Gatwick Northern Runway

TR020005

National Highways Comments on any Submissions Received by Deadline 8

Appendix 19.8.1 Public Rights of Way Management Strategy Version 3

Temporary Diversion 355a_355_Sy

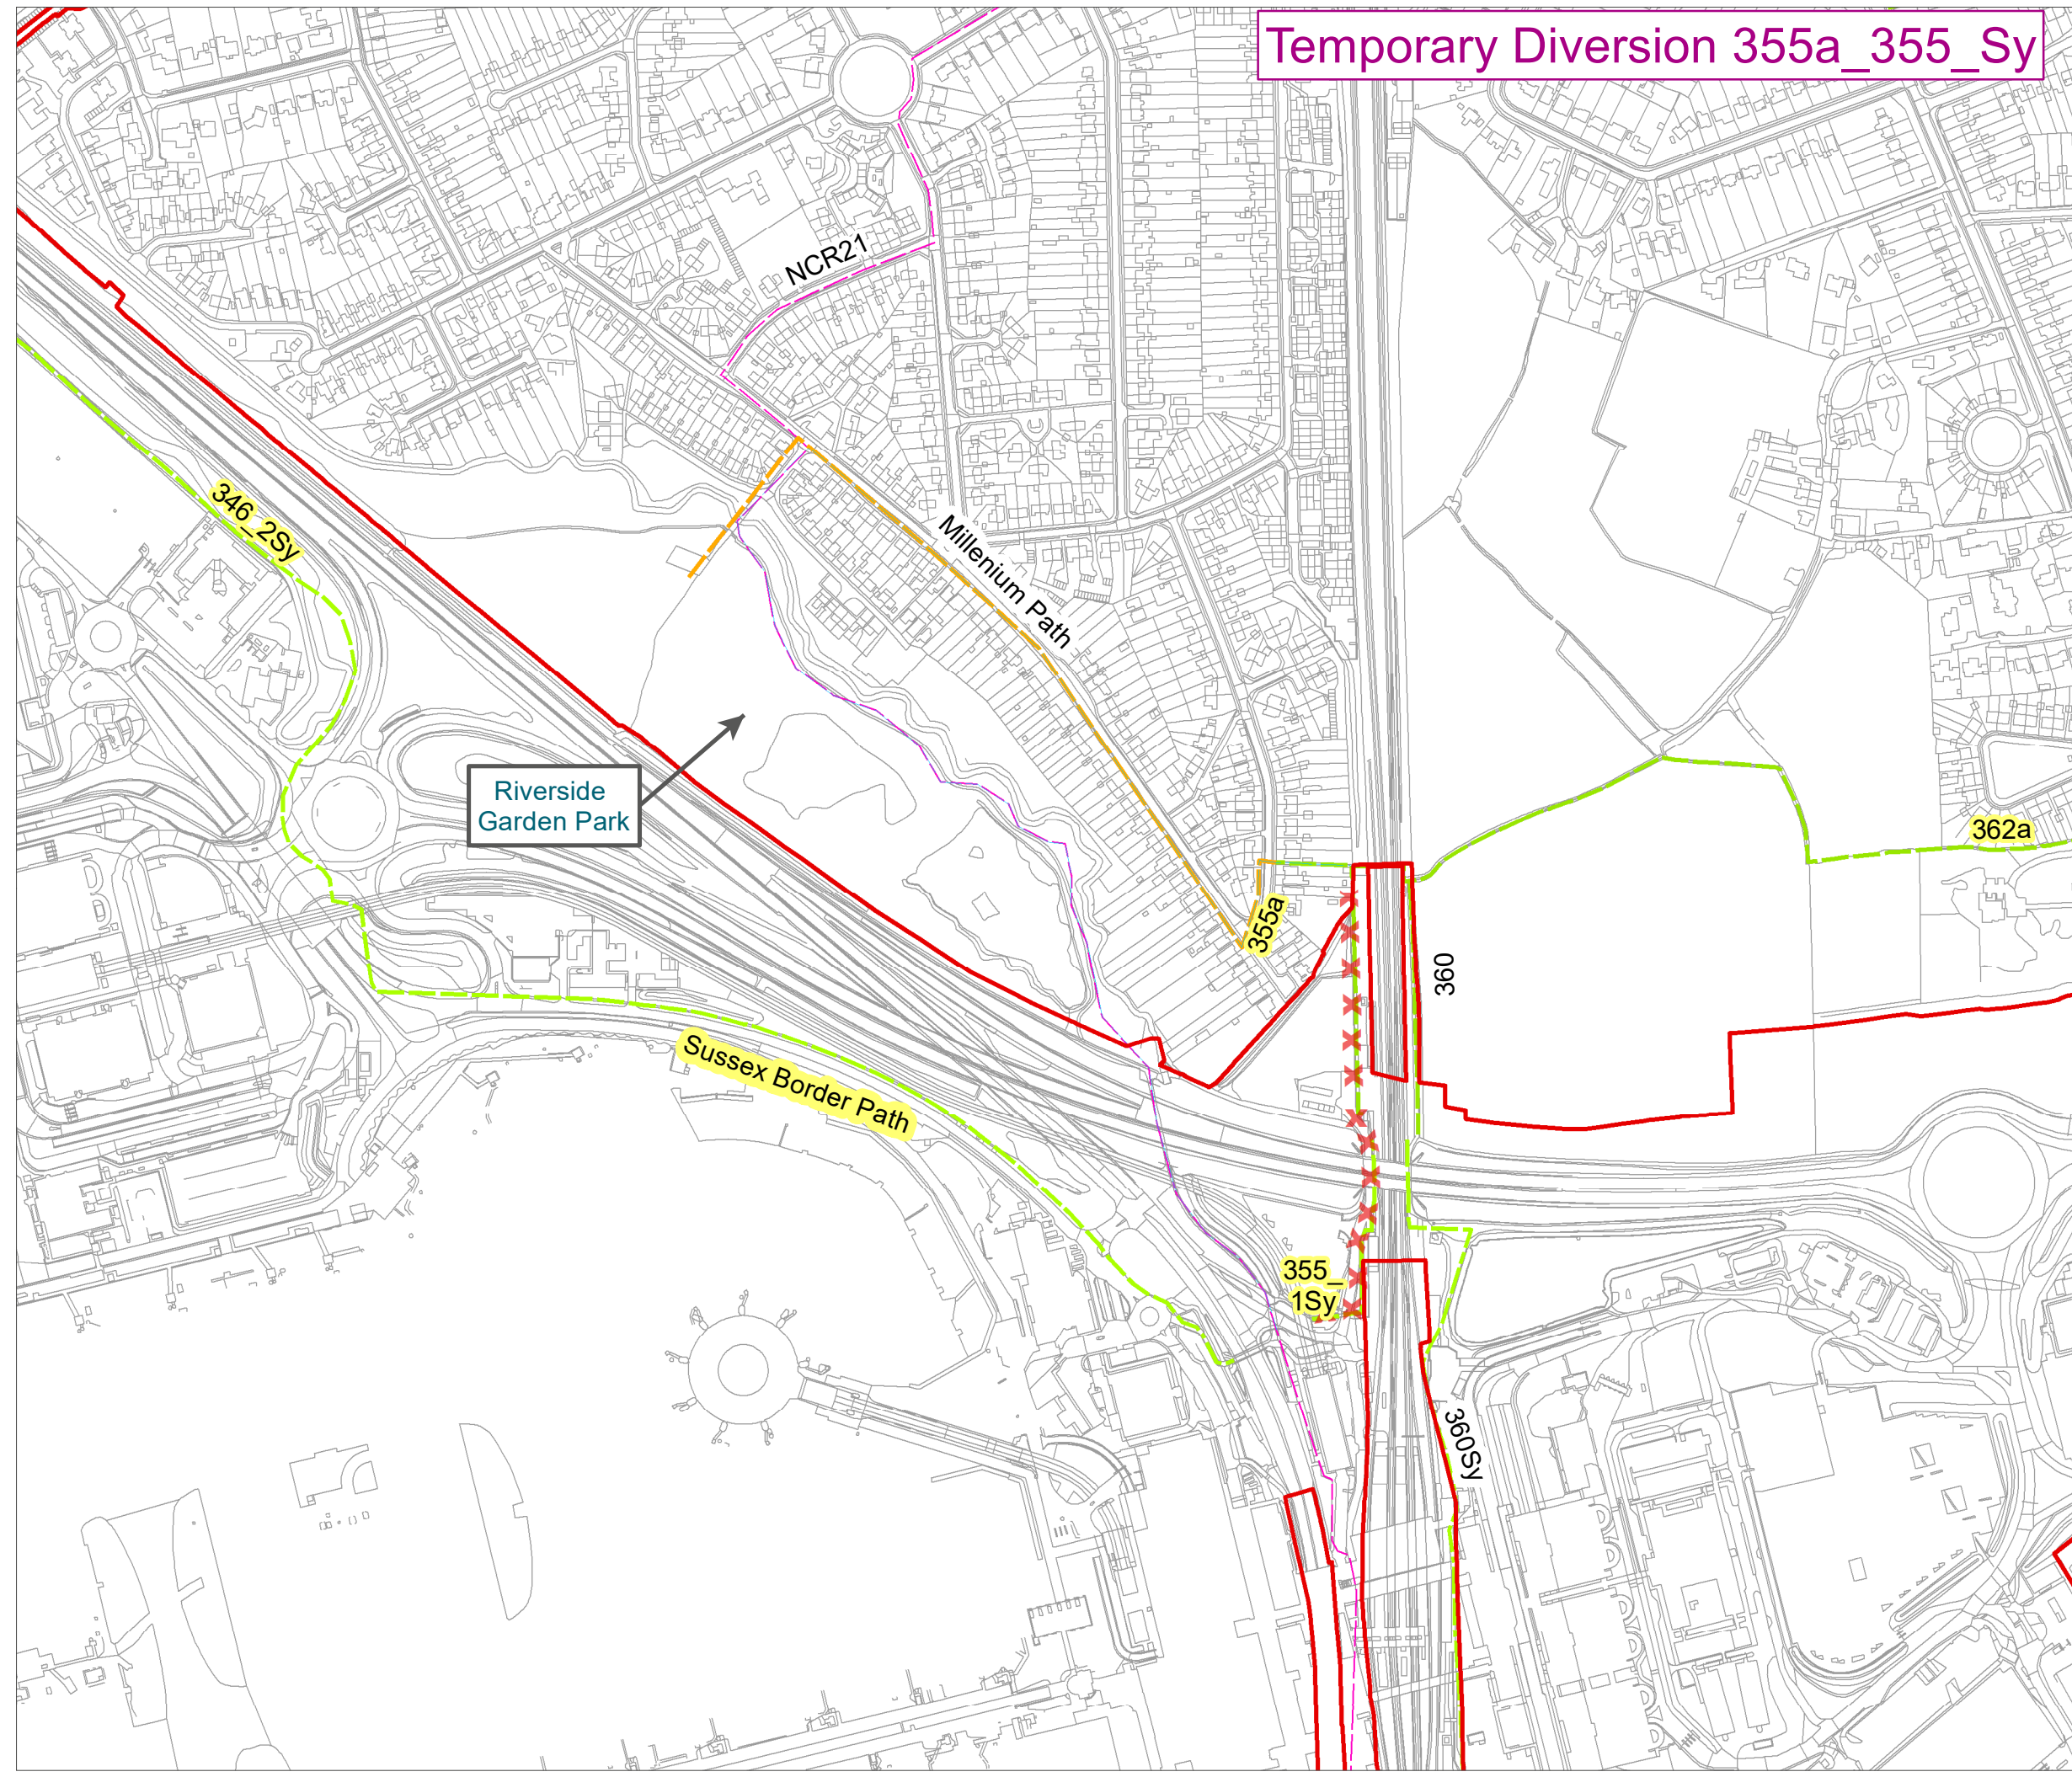
Reference	Examination Library Reference Number	Statement	National Highways Comment
Annex 1: Fire A (b)	REP8-089		National Highways notes that the diversion of this route would be via the National Cycle Route 21, as reported in Table 4.1.1, however according to the Figure Key, the diversion route is not shown in Figure A(b) contained in Annex 1. National Highways requests that this is updated for clarity.
